Project Name: Super Star Car Wash - Falcon, CO
Project No.: 020441-01-001 // PPR-21-008

This letter is in response to the letters dated September 16, 2021.

SDP Plan Redlines

SEAL		
NOT FOR CONSTRUCTION		
DESIGN	DRAWN	CHKD
SWK	SWK	TOP
SCALE	H: 1" = 20' V: 1" = XXX'	
JOB No.	020441-01-001	
DATE :	02/09/2021	
SHEET	C2.0

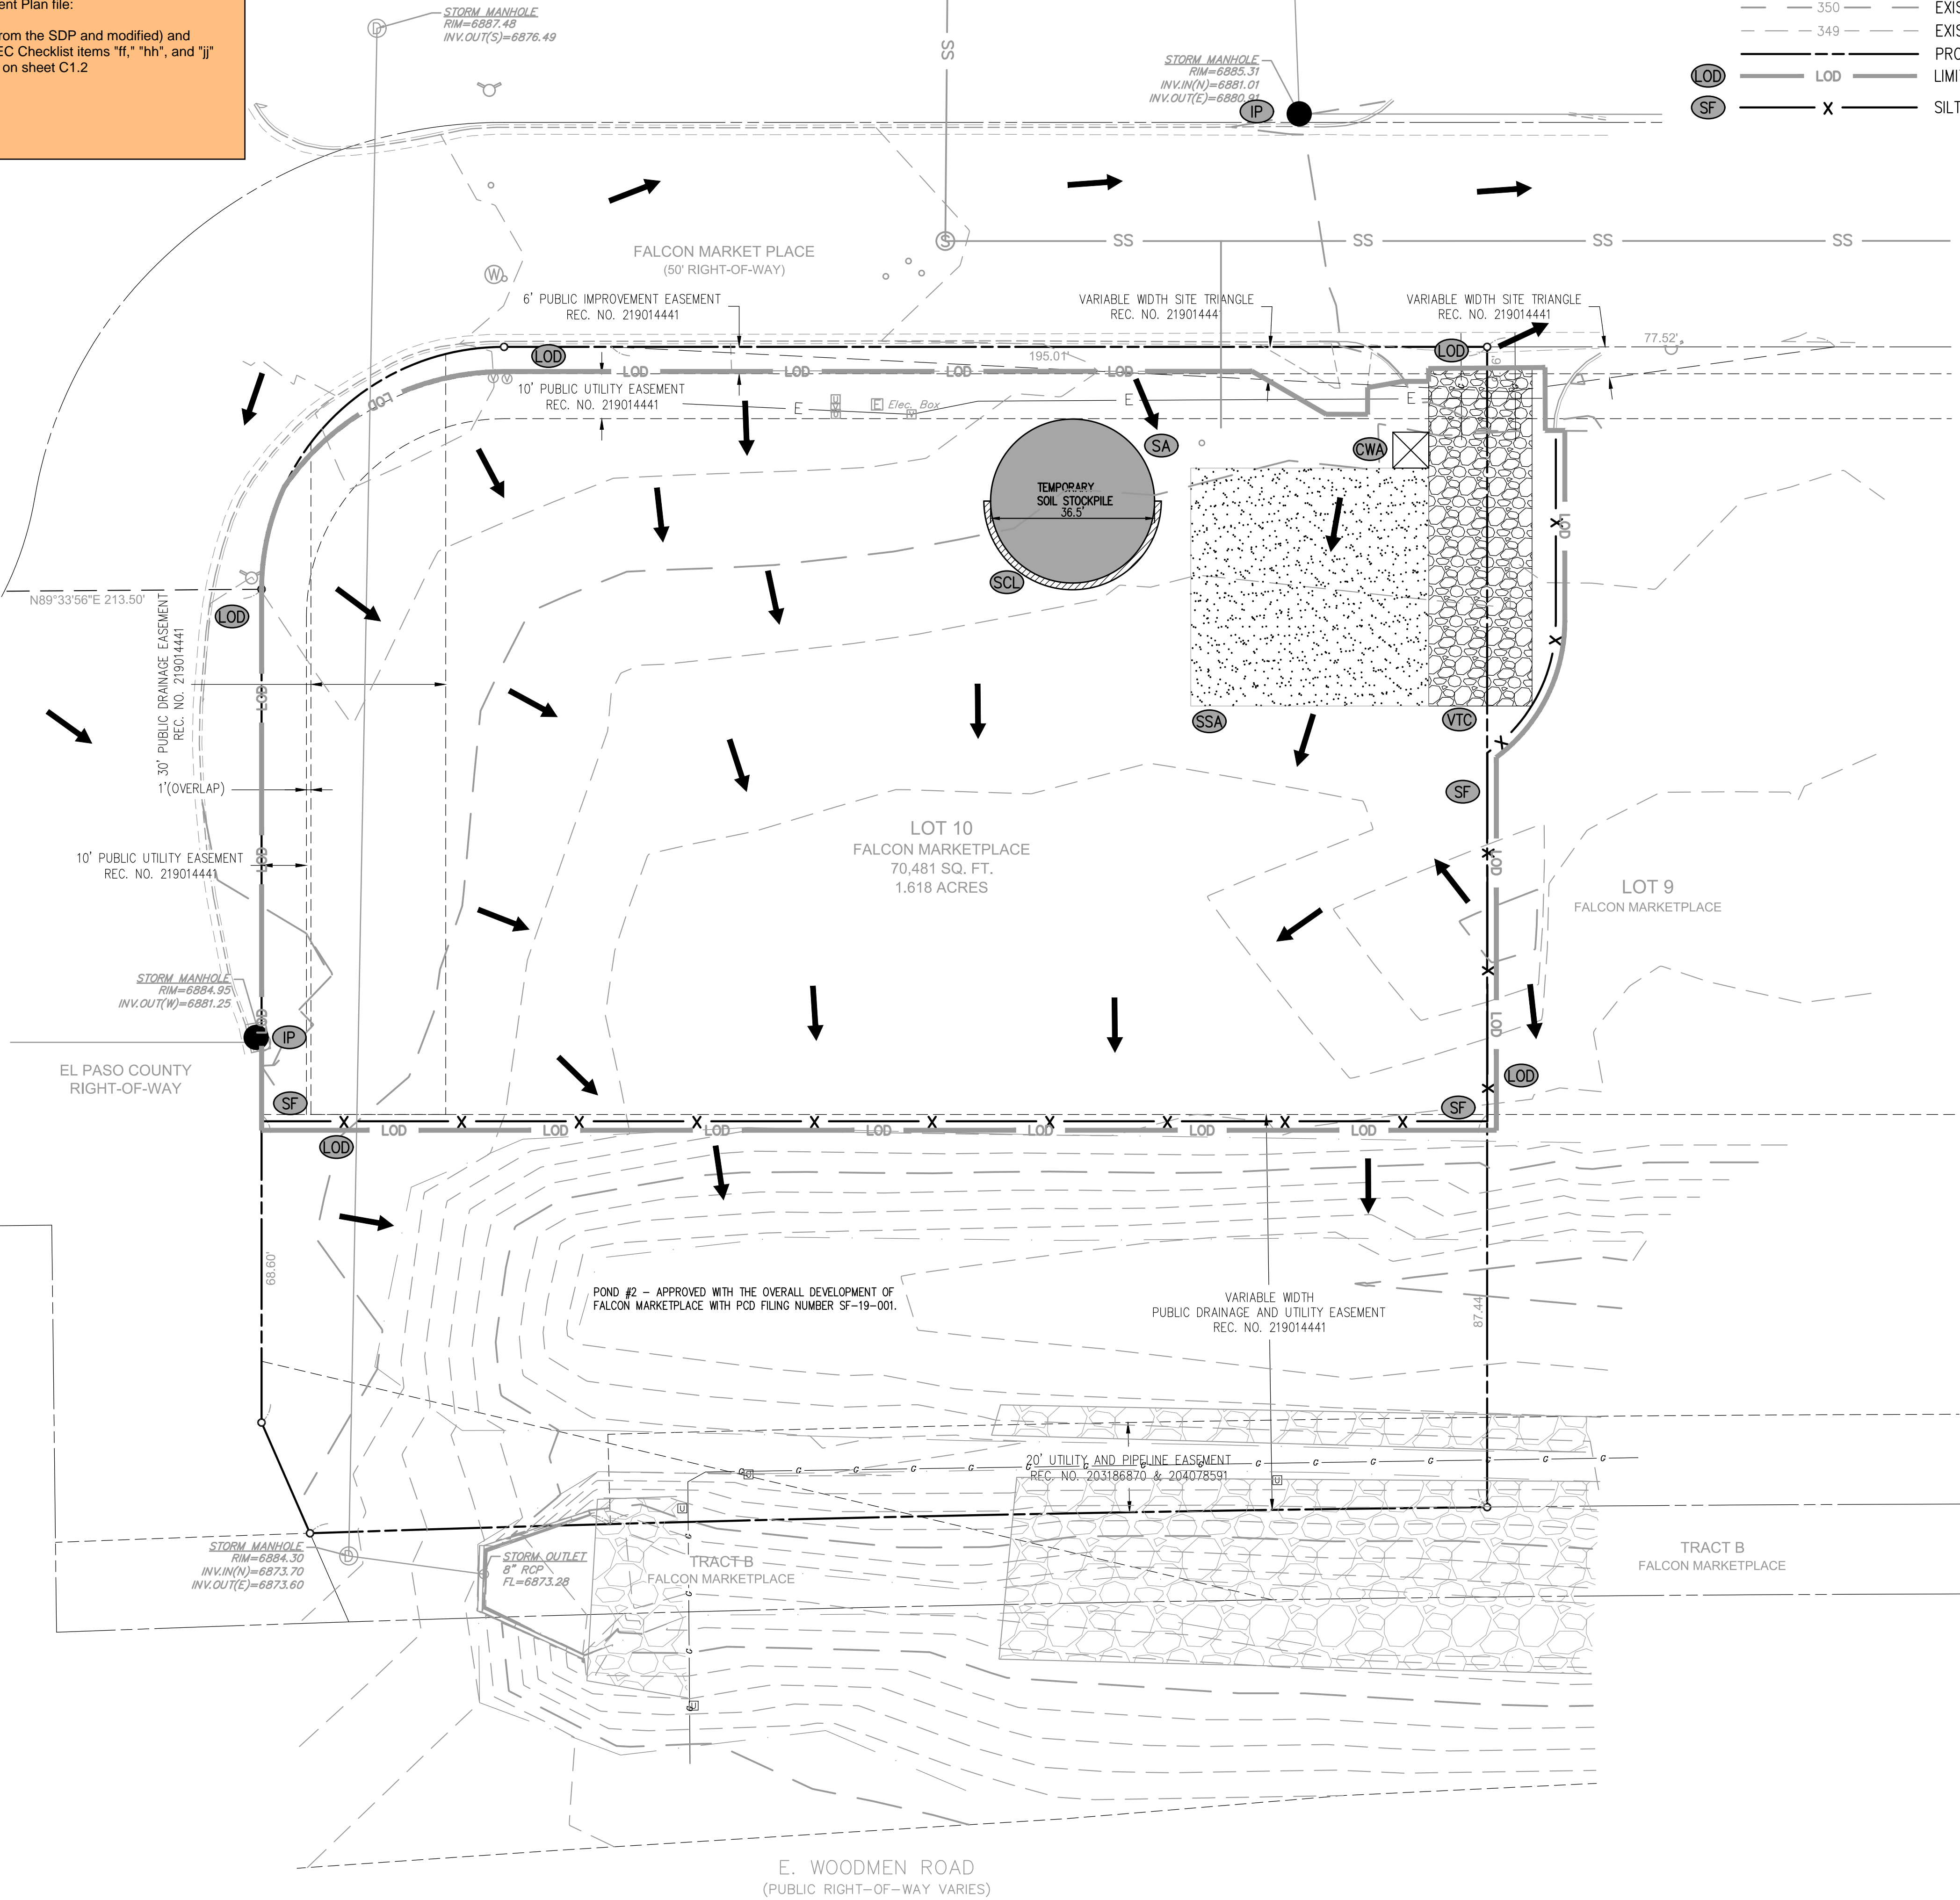
Please remove sheets C2.0 through C4.0 and incorporate as separate GEC plan and add a note page and cover sheet for the GEC plan.

Response: The GEC plans have been removed from the SDP set and a new GEC set has been created.

SHEET C2.1

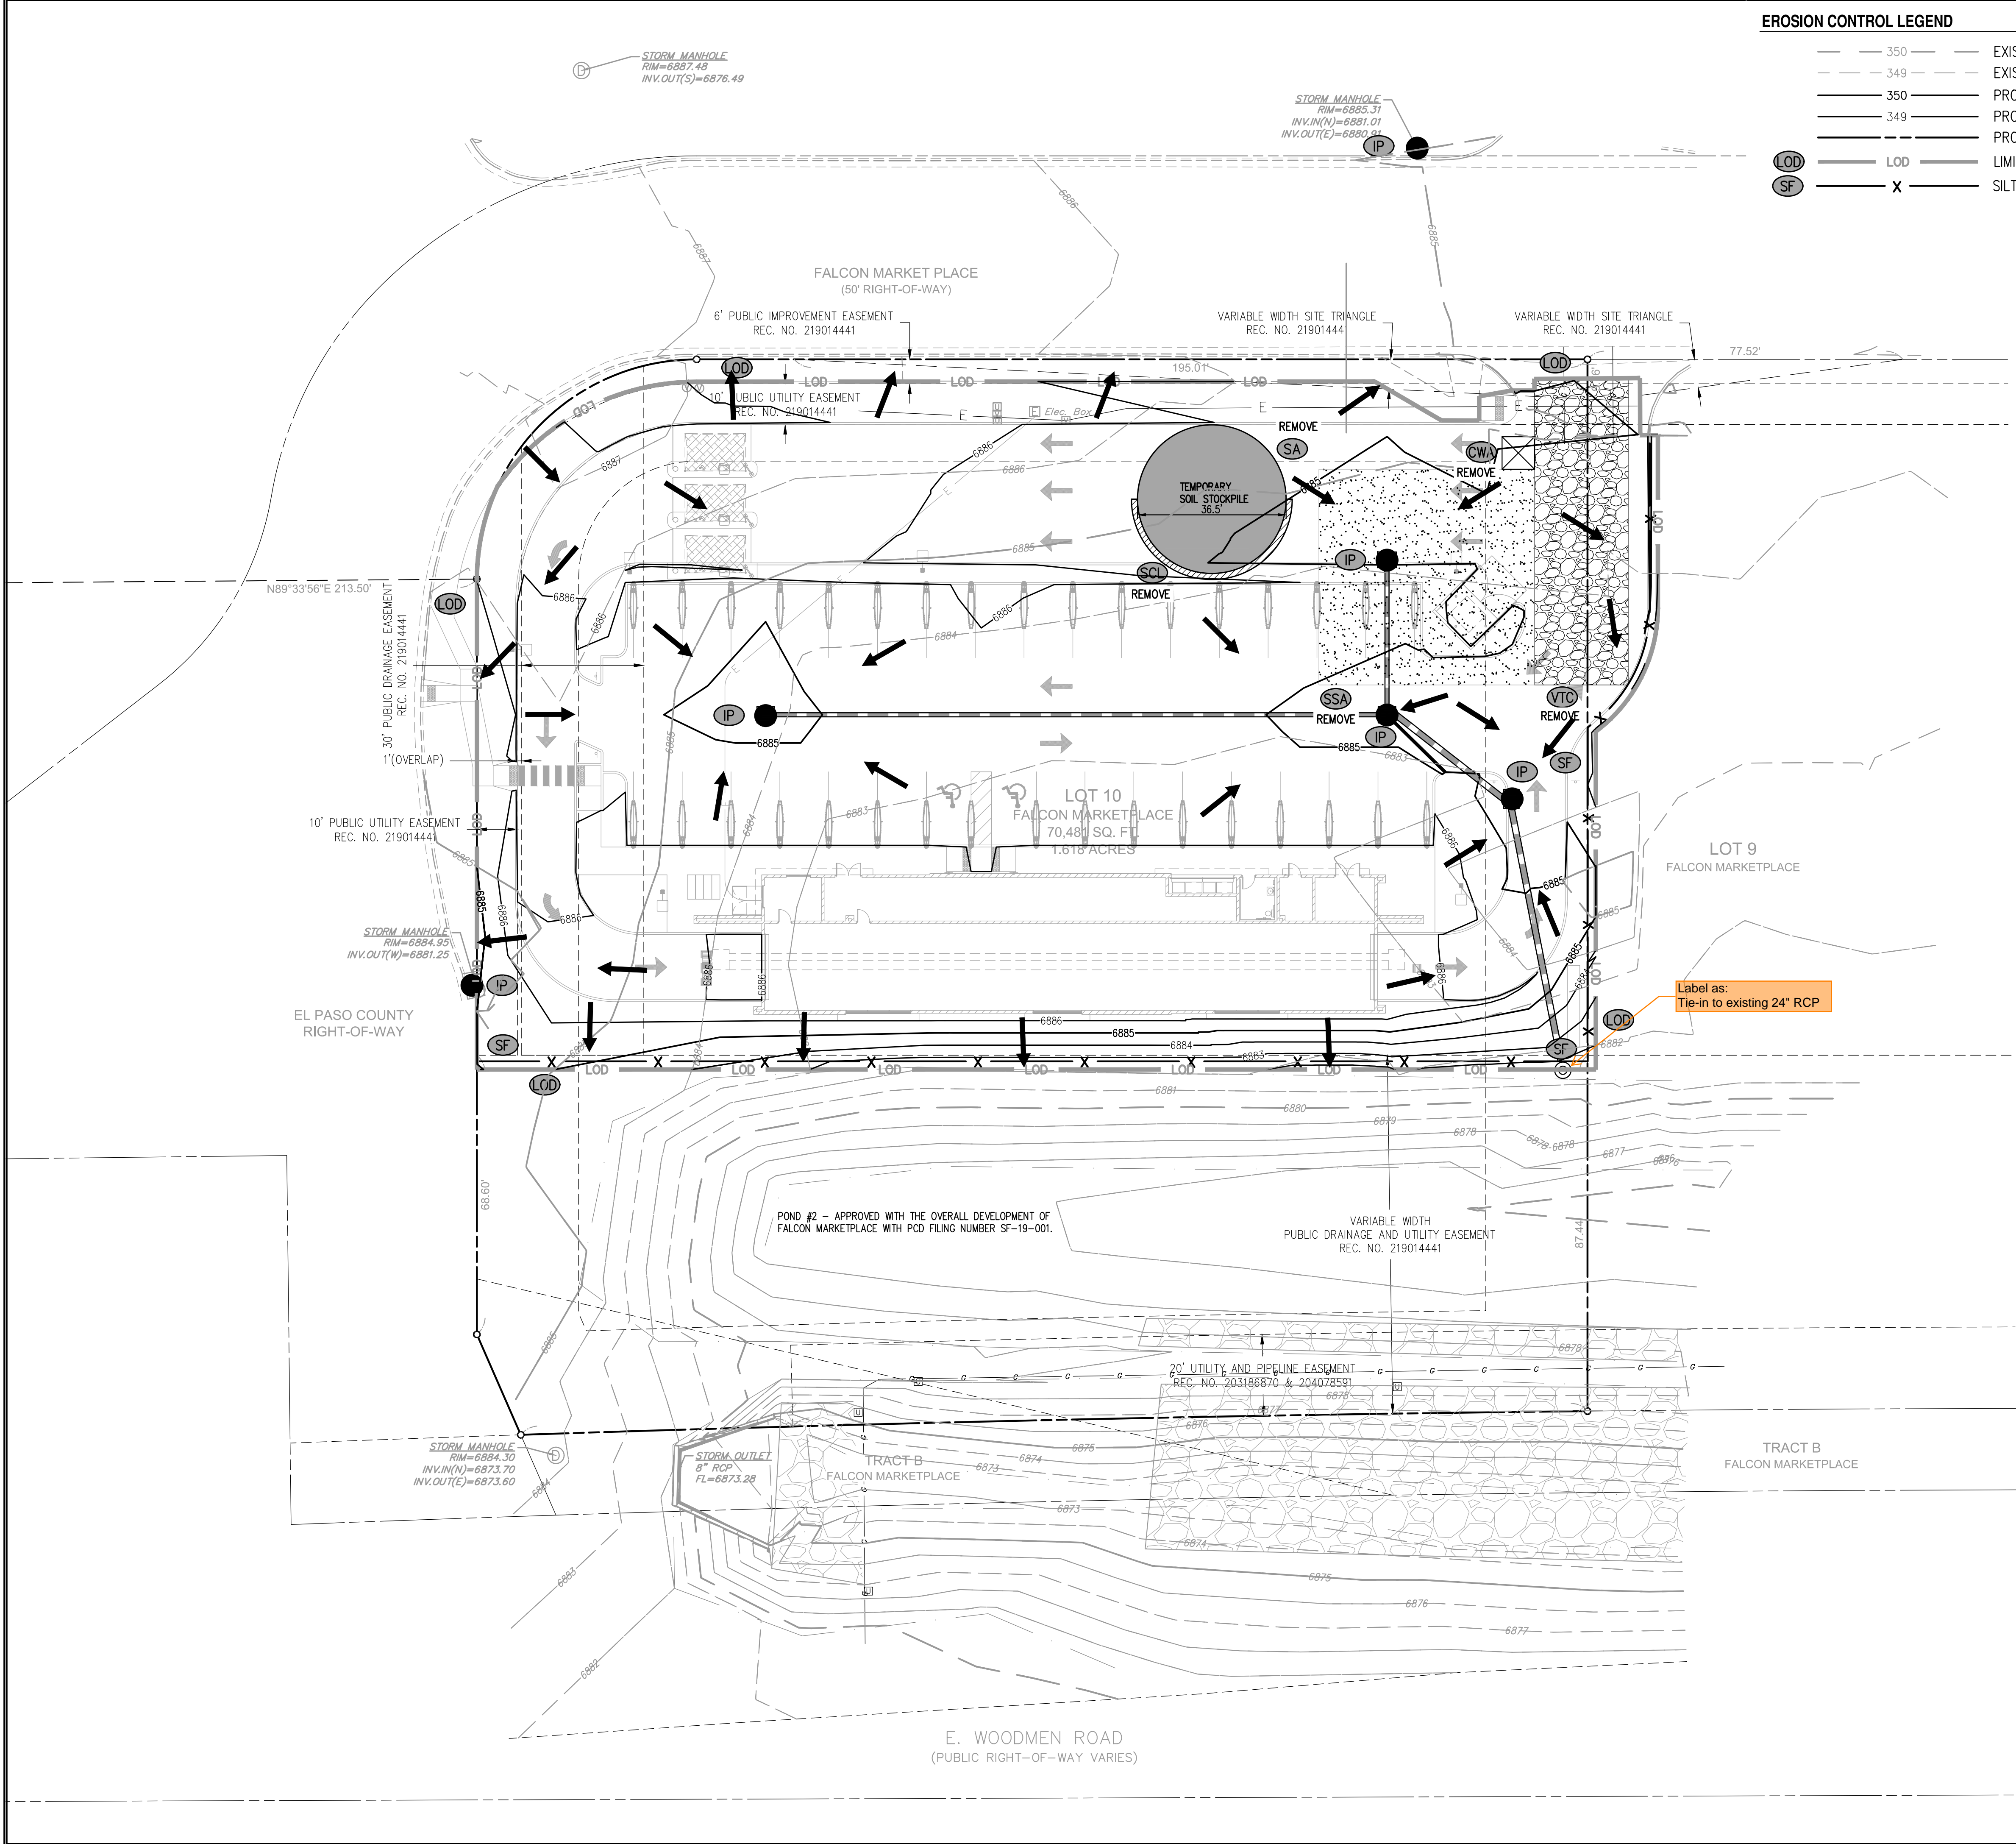
Revise text to match these notes shown on the GEC Checklist.

Response: Text revised to match GEC Checklist
